**BOTLEY WEST SOLAR FARM
OXFORDSHIRE HOST AUTHORITIES
RESPONSE TO ISH2 ACTION POINT 16
DEADLINE 6 | MONDAY 20 OCTOBER 2025**

OXFORDSHIRE HOST AUTHORITIES RESPONSE TO ISH2 ACTION POINT 16

OHA to provide clarification note regarding further reductions to solar installation, the methodology used to define those areas for reduction and the impacts you feel remain.

Figure 2 - Northern Area Masterplan Changes Animation

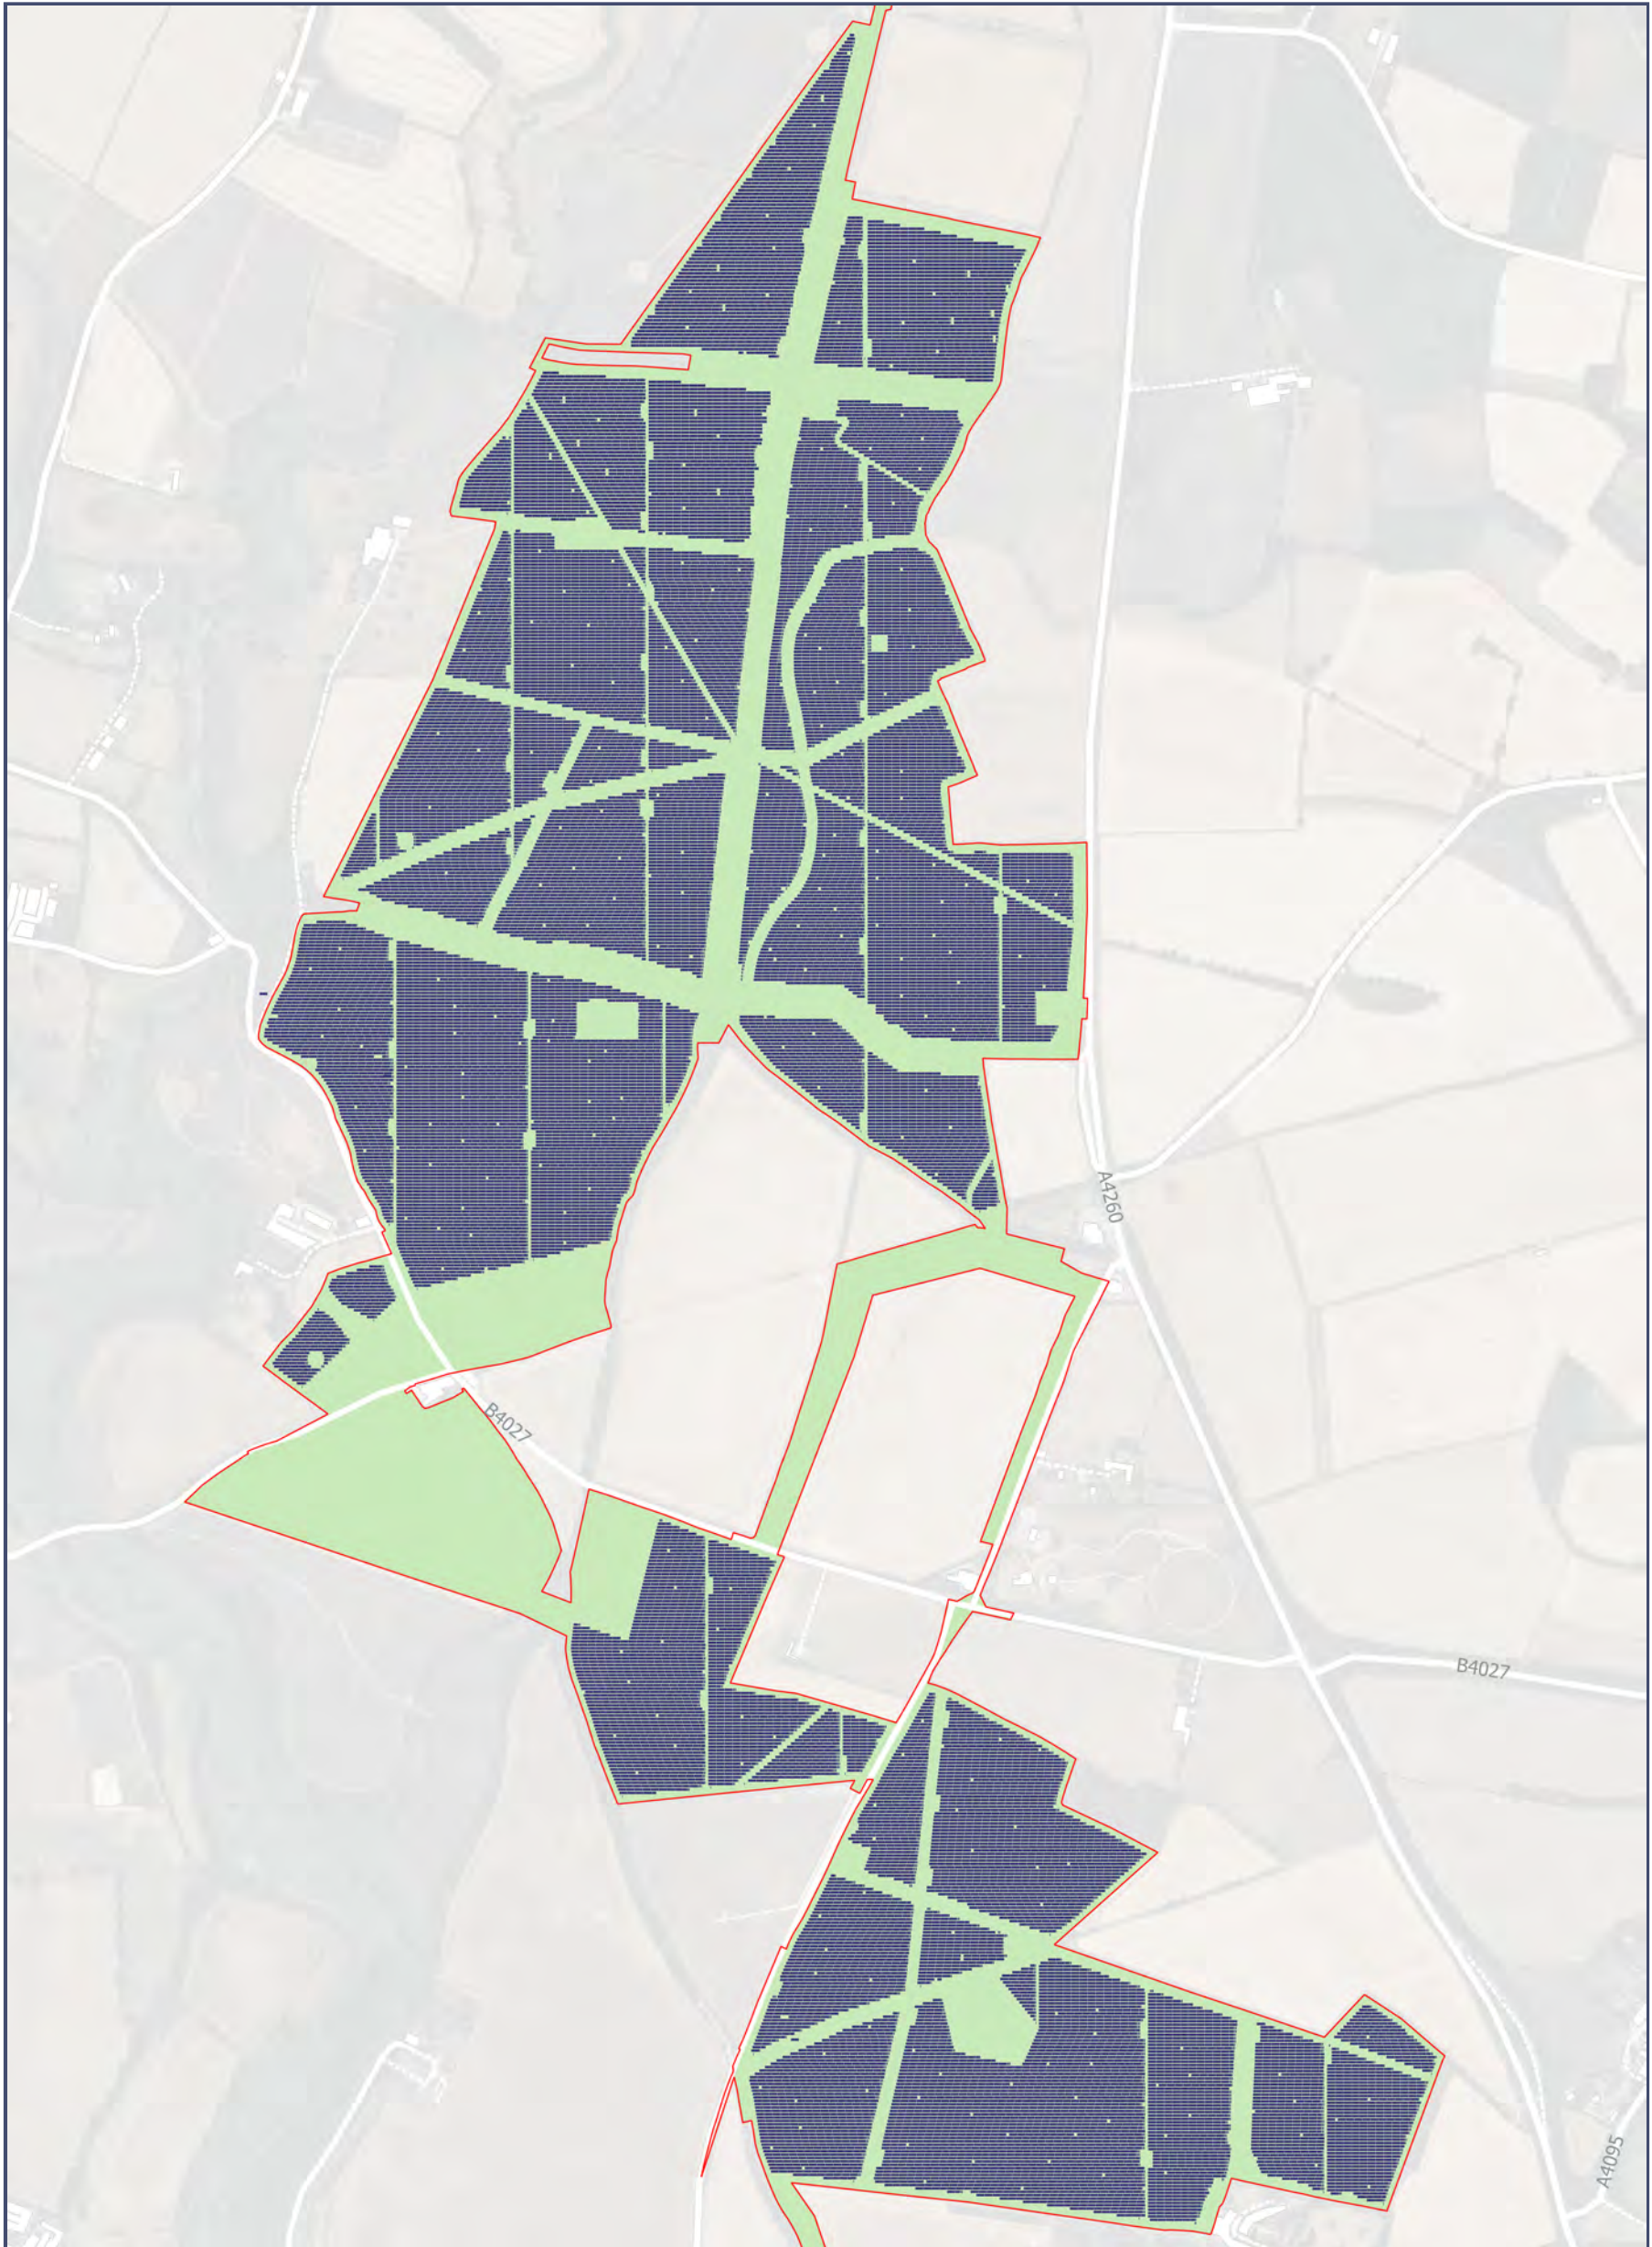
1.11 (part of)	Nr Sansom's Farm	9, 10 (distant)	Note that no panels are proposed in the southern part of the field, as it has been identified as an area of Archaeological Interest on the applicant's masterplan [CR2-026]	<p>Panels should be removed from the lower ground, up to the break in slope, and a line drawn running east-north-east from Hordley Farm.</p> <p>Reason: to reduce effects upon residential visual amenity in the views east from Hordley Farm, where effects are likely to be considered overbearing.</p>	x	x

1.12	Nr Sansom's Farm and Hordley House	8, 9,		<p>Small areas of outlying panels on elevated land, either side of footpath. Panels would be isolated from the rest of the development as the remainder of field 1.12 has been identified as an area of archaeological interest on the applicant's masterplan [CR2-026]</p> <p>Reason: to reduce effects upon residential visual amenity, in the views south from Hordley Farm, where effects are likely to be considered overbearing; and to reduce effects on users of the footpath.</p>	x	x

Parcel No.	Location	Relevant Viewpoints (VPs)	Site Character/ Notes	Explanation	Reasons for Removal	
					Landscape/ Visual/Residential	Heritage
1.13	Nr Sansom's Farm and Oxford School of Drama	9, 11, 12 (distant)		<p>Areas of outlying panels on elevated land. Panels would be isolated from the rest of the development as the remainder of field 1.13 has been identified as an area of archaeological interest on the applicant's masterplan [CR2-026]</p> <p>Reason: to reduce effects upon residential visual amenity, in the views south from Sansom's Farm, Sansoms Cottage, Sansom's Platt Farm, where effects are likely to be considered overbearing; and to reduce effects on users of the Oxfordshire Way footpath which runs along the course of the Roman Road, now reflected as Stratford Lane. Also, to remove panels from the steep ground which drops down to the River Glyme and the sloping ground which drops down to Sansom's Platt. Panels would be more widely visible when located on steeper slopes, and would visually conflict with the topography.</p>	x	x

1.14	Nr Sansom's Farm	11, 13	Note that there is an existing solar development at the southern end of field, with which there would be cumulative effects	<p>Areas of outlying panels on elevated land. Panels would be isolated from the rest of the development after archaeological areas have been removed. The north east of field 1.14 has been identified as an area of archaeological interest on the applicant's masterplan [CR2-026]</p> <p>Reason: Reduce potential for overbearing effects on the residential visual amenity of Weaveley Farm.</p>	x	x

1.17 (south-eastern third)	Nr Shipton Slade	No VPs		<p>Removal of panels to link into ground levels and area of archaeology. Setting and views to and from Shipton Slade Farm.</p> <p>Reason: to reduce effects upon residential visual amenity, in the views north-west from Shipton Slade Farm, which is an area very close to the windows and gardens of properties within this historic hamlet, where effects are likely to be considered overbearing.</p> <p>Also, an area which is potentially visible from the area of the Column of Victory within Blenheim Park, noting that the Column of Victory can be seen from here.</p>	x

1.18 (southern half)	Nr Shipton Slade	No VPs		<p>Removal of panels from setting and views to and from Shipton Slade Farm. Removal of isolated field of panels, if areas to west of Shipton Slade Farm are removed.</p> <p>Reason: to reduce effects upon residential visual amenity, in the views north-east from Shipton Slade Farm, which is an area very close to the windows and gardens of properties within this historic hamlet, where effects are likely to be considered overbearing.</p>	x

Figure 3 - Central Area Masterplan Changes Animation

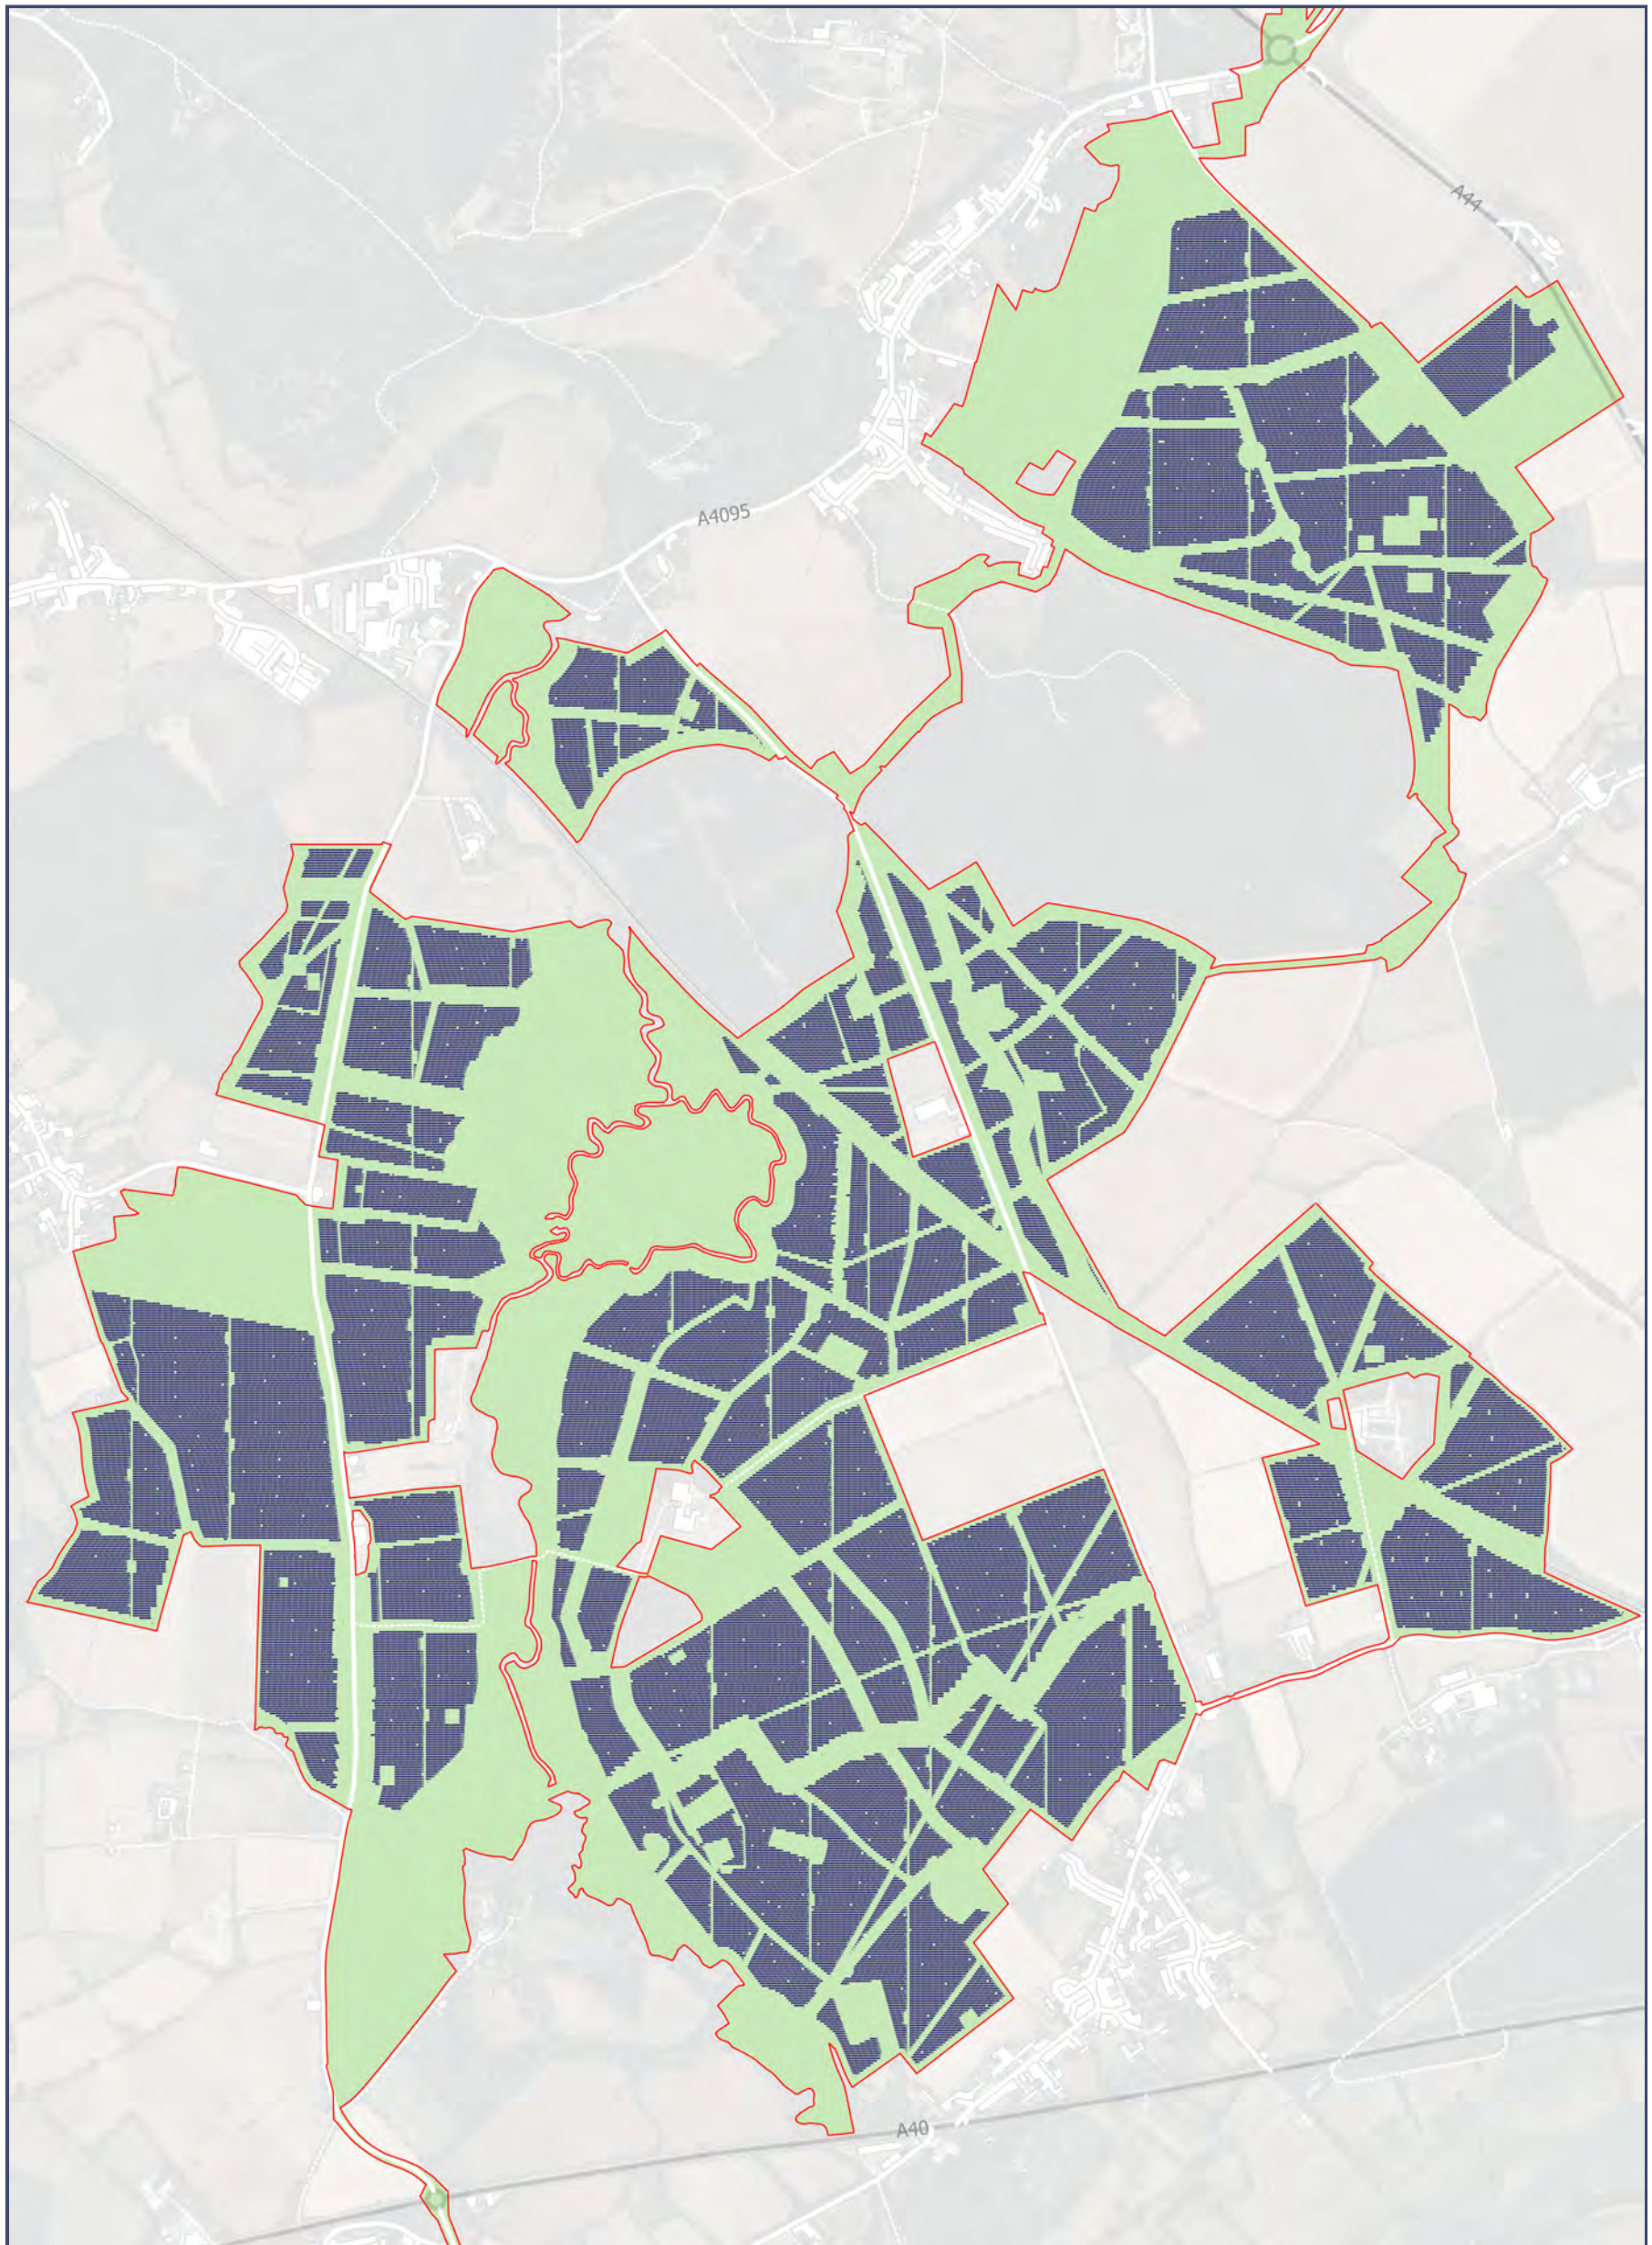
2.1	East of Bladon	No VPs	Panels removed as part of Change 2 request	<p>Reason: this area is within the setting of Blenheim, and very close to residential properties along the south-east side of Grove Road, where effects are likely to be considered overbearing.</p> <p>It is crossed or paralleled by public right/s of way and is close to a community recreation ground used as an educational resource by local schools.</p>	x	x

Parcel No.	Location	Relevant Viewpoints (VPs)	Site Character/ Notes	Explanation	Reasons for Removal	
					Landscape/ Visual/Residential	Heritage
2.3	East of Bladon	16, 17		Reason: this area is within the setting of Blenheim, and close to residential properties along the south-east side of Grove Road. It is crossed or paralleled by public right/s of way and is close to a community recreation ground used as an educational resource by local schools.		x

2.7	East of Bladon	18, (17, 16)		Reason: this area is within the setting of Blenheim, and close to residential properties along the south-east side of Heath Lane. It is crossed or paralleled by public right/s of way and is close to a community recreation ground used as an educational resource by local schools. It, together with area 2.8 and 2.11 is an area of higher land running up to Bladon Heath woodland and the Shakespeare Way PRoW, which is highly visible from the area around the A44/A4095 roundabout (vp16), the southern side of Woodstock and the north east end of Bladon.	x

2.11	East of Bladon	18, 16		Reason: this area is crossed or paralleled by public right/s of way. It, together with area 2.7 and 2.8 is an area of higher land running up to Bladon Heath woodland and the Shakespeare Way PRoW, which is highly visible from the area around the A44/A4095 roundabout (vp16), the southern side of Woodstock and the north-east end of Bladon.	x

2.12 (southern part)	Nr Begbroke	32		Area to the south of the footpath route to be removed. Reason: Remove panels on higher ground to the south of Shakespeare's Way, to reduce visual effects upon users, and effects on residential visual amenity of Begbroke. Remove the outlying and disjointed areas of proposed panels. Areas of archaeological interest have been identified in field 1.12 on the applicant's masterplan [CR2-026]	x

2.61	East of Pinsley Wood	21, 22		Single field to west of road, running up to and east of Pinsley Wood. Footpath routes would run through the through solar panels. Reason: Remove panels to reduce visual effects upon users of the Public Right of Way and B4449 to the north east of Church Hanborough. Remove panels within the landscape and visual setting of Church Hanborough. Remove panels so that drivers to not pass through development both to the east and the west of the road, to provide visual relief.	x

2.115 (upper half)	Church Hanborough	24, 25, 26, 38	No proposed panels across a small section of the northern part of this field	<p>Reason:</p> <p>Remove panels across the rising ground within the important landscape and visual, and historic setting of Church Hanborough, an area which is seen in views looking across the valley to the historic village and church, from the east and south east.</p> <p>Remove panels to reduce visual effects upon users of the Public Right of Way and B4449 to the north east of Church Hanborough, and on Owls Leat (property to the east of the road where effects are likely to be considered overbearing).</p> <p>Remove panels so that drivers do not pass through development both to the east and the west of the B4449, to provide visual relief.</p>	x
